DECISION DELEGATED TO HEAD OF PLANNING
--

Application No:	H16-0272-25	Applicant:	Mrs S Prowting
Proposal:	Proposed first floor side extension		
Location:	39 Helmsley Way Spalding		
Terminal Date:	4th July 2025

title
PROPOSED FIRST FLOOR PLAN

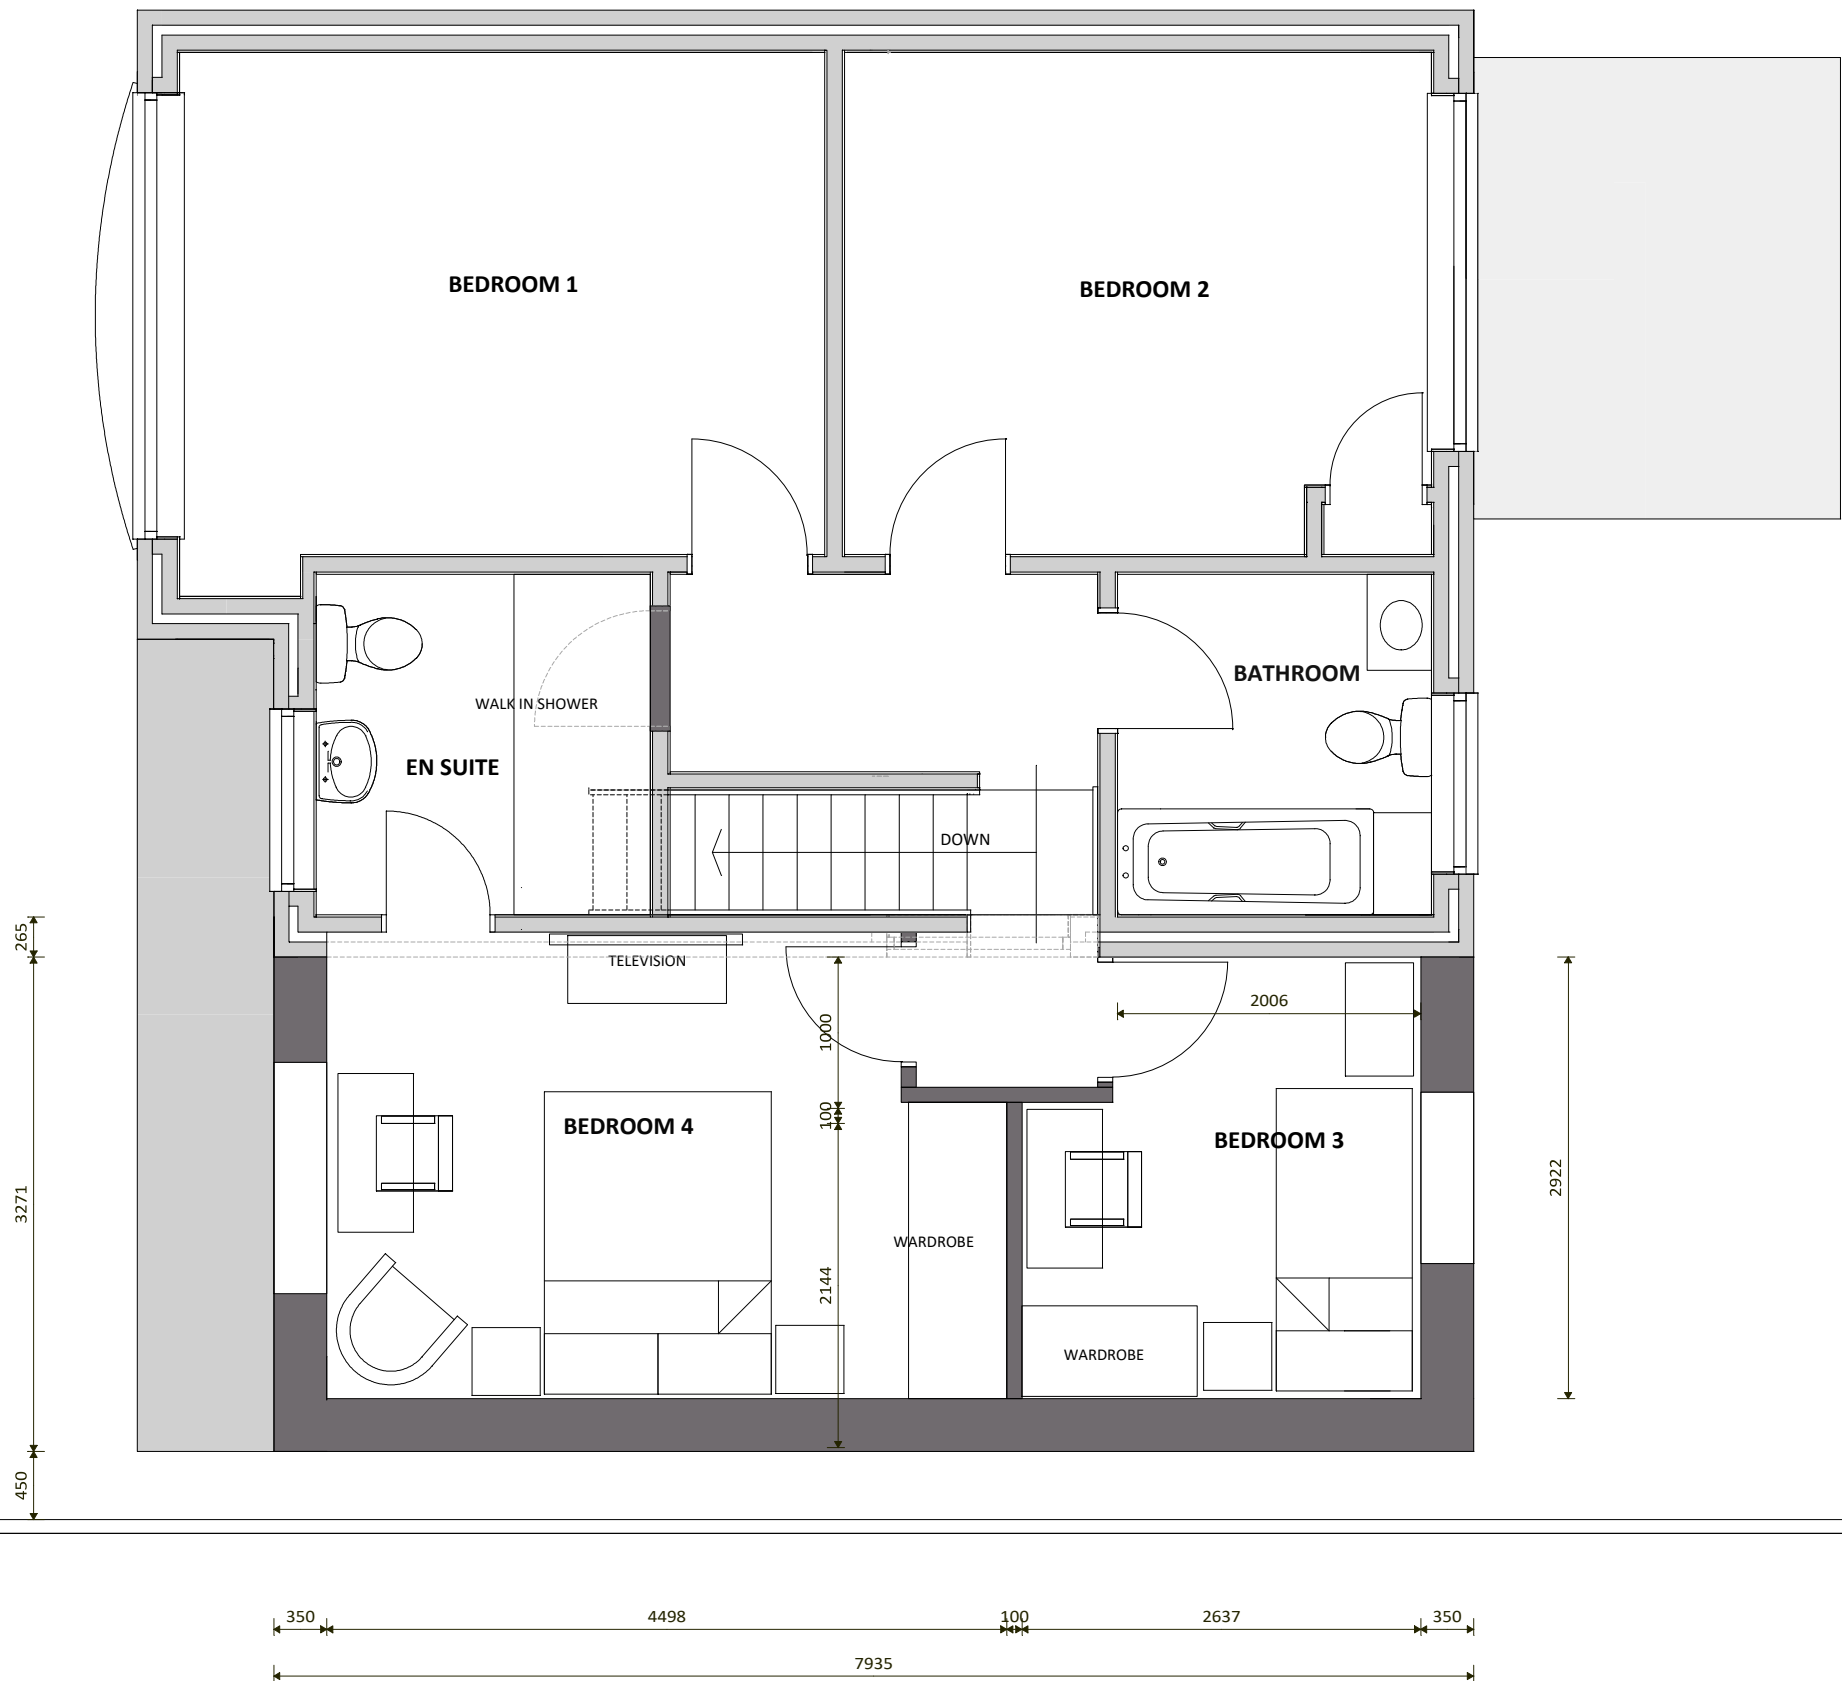
The first-floor extension would run the length of the existing ground floor component, measuring 7935mm (depth) by 3271mm (width). The eaves and ridge height would be consistent with the host, set at 4650mm and 6100mm respectively.

title
PROPOSED ELEVATIONS

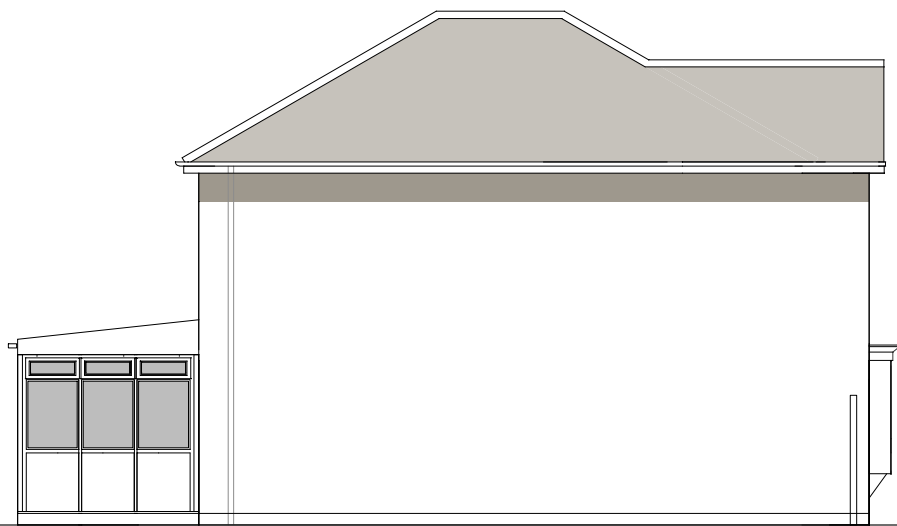
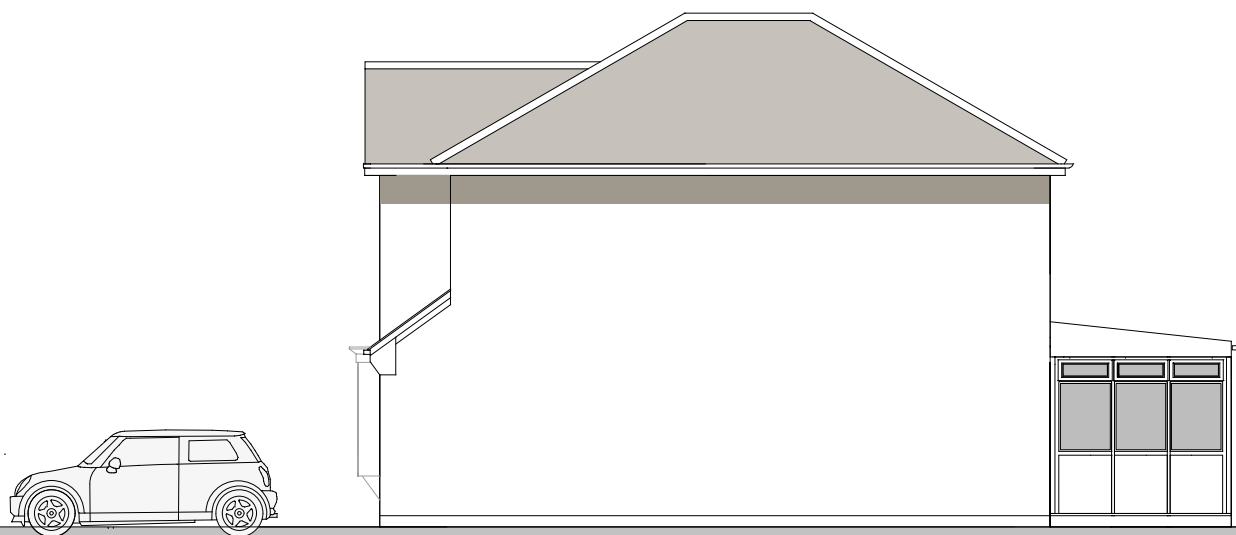
The proposed extension is well integrated into the host dwelling, appearing as a natural continuation of the host dwelling. The use of materials to match the host and the integration of the roof pitch ensures that this is the case.

The proposal, to a certain extent, would be an outlier in the immediate area. In the immediate locale, there is a relatively high degree of consistency, where flat roof garages are prevalent. To a certain extent, extending above this existing component would break from the built form of the area. However, within the broader estate, comparable designs do exist which would help naturalise the proposal. In any event, the flat roof component is not particularly beneficial to the appearance of the area, appearing utilitarian and of no design merit. As such, the loss of this component would break from the uniformity, but would not worsen the overall appearance of the dwelling.

The proposed first floor extension would not significantly overlook its neighbours. The additional rear and front windows would not offer significant views towards neighbouring dwellings, and any views offered would be no more harmful than what is currently available to residents.

title	PARKING & SITE PLAN
contract	MR & MRS PROWTING

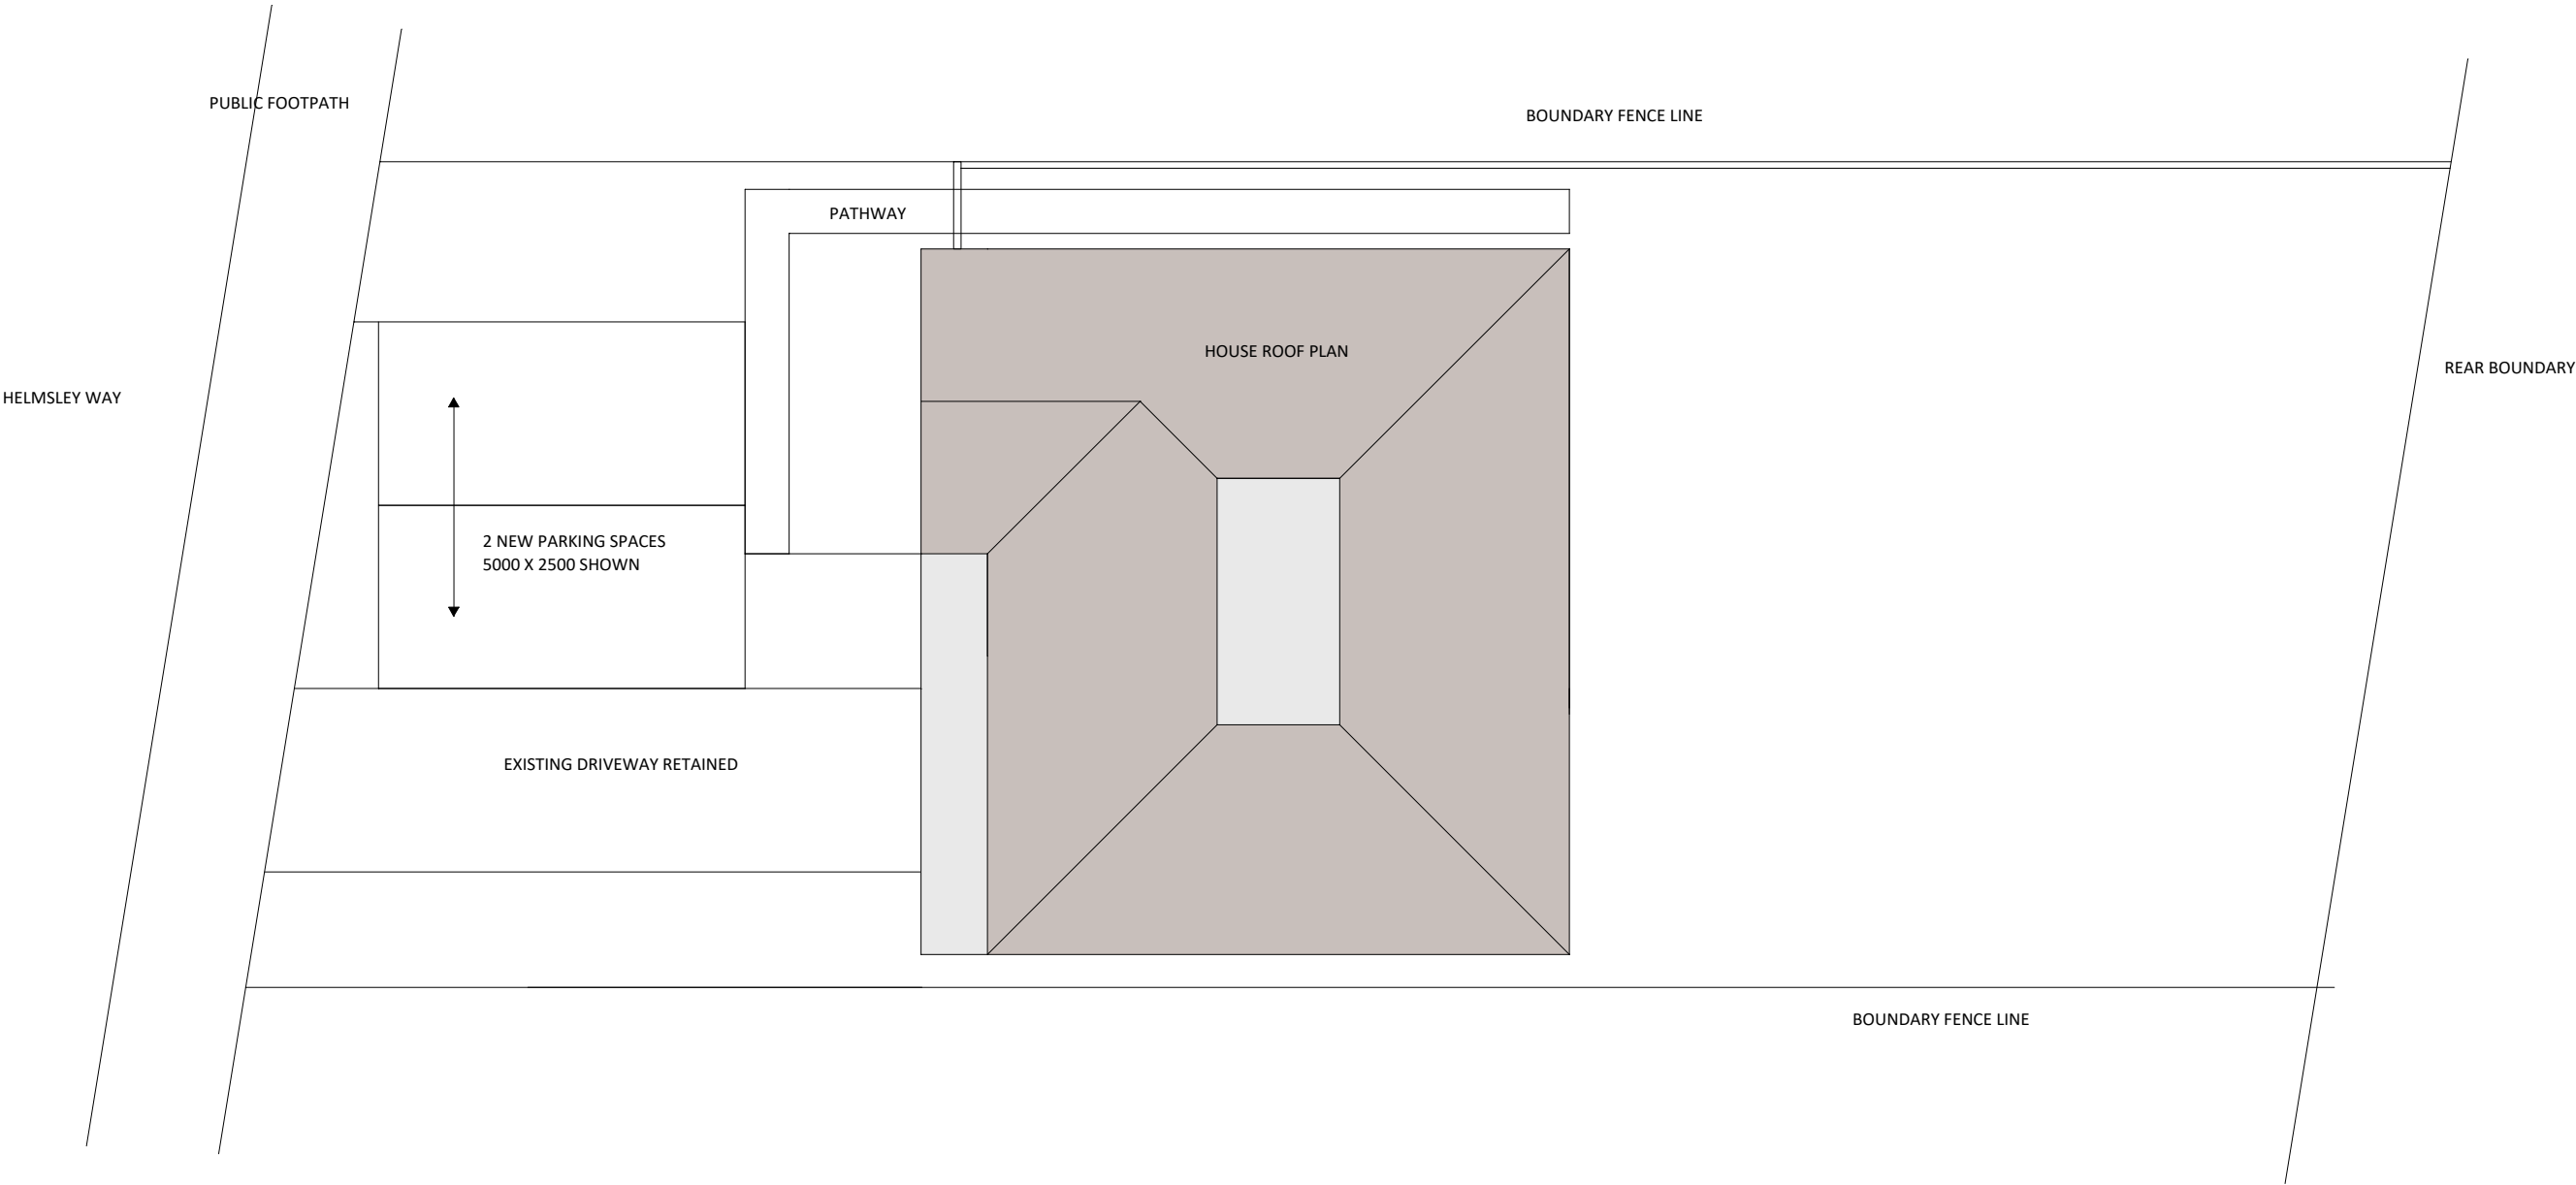
Requests additional information - "The proposed site plan should show the parking - a 4-bed house should provide 3 parking spaces".

Objections: "The applicant intends to construct a two storey wrap around extension, extending to the side and rear of the dwelling, all within 9 metres of the aforementioned Board maintained watercourse. The d Proposed Site Plan states that the side extension will finish 10.6m from the edge of the property boundary. However, the drawing fails to include the measurement of the section of extension closest to the eastern states that the rear extension, measures 3m wide, therefore, this part of the extension will finish 3m closer to the eastern boundary than the side extension. We believe that the overall extension will finish 7.6m from the edge of the property boundary. We believe that the property boundary finishes on the brink of the Board watercourse. Resultantly, This proposal is unacceptable Planning and Byelaw Strategy as permanent structures must be positioned a minimum of 9 metres from the edge of the closest brink of the open watercourse. Therefore, the Board objects to this proposal."

"The proposal is for side & rear extensions. The extension will see a three-bed dwelling with a garage increase to a four-bed dwelling without a garage. The Proposed site plan shows the parking for three vehicles. The proposal will not have an adverse impact on the public highway."

"We are pleased to see that the applicant has updated their plans in response to the Board's comments. The applicant's initial proposal included the construction of an extension within 9metres of the Board's watercourse which goes against the Board's Planning and Byelaw Strategy. The applicant now proposes to construct the extension outside of the 9metre Byelaw Zone. In light of these changes, the Board would like to remove our objection."
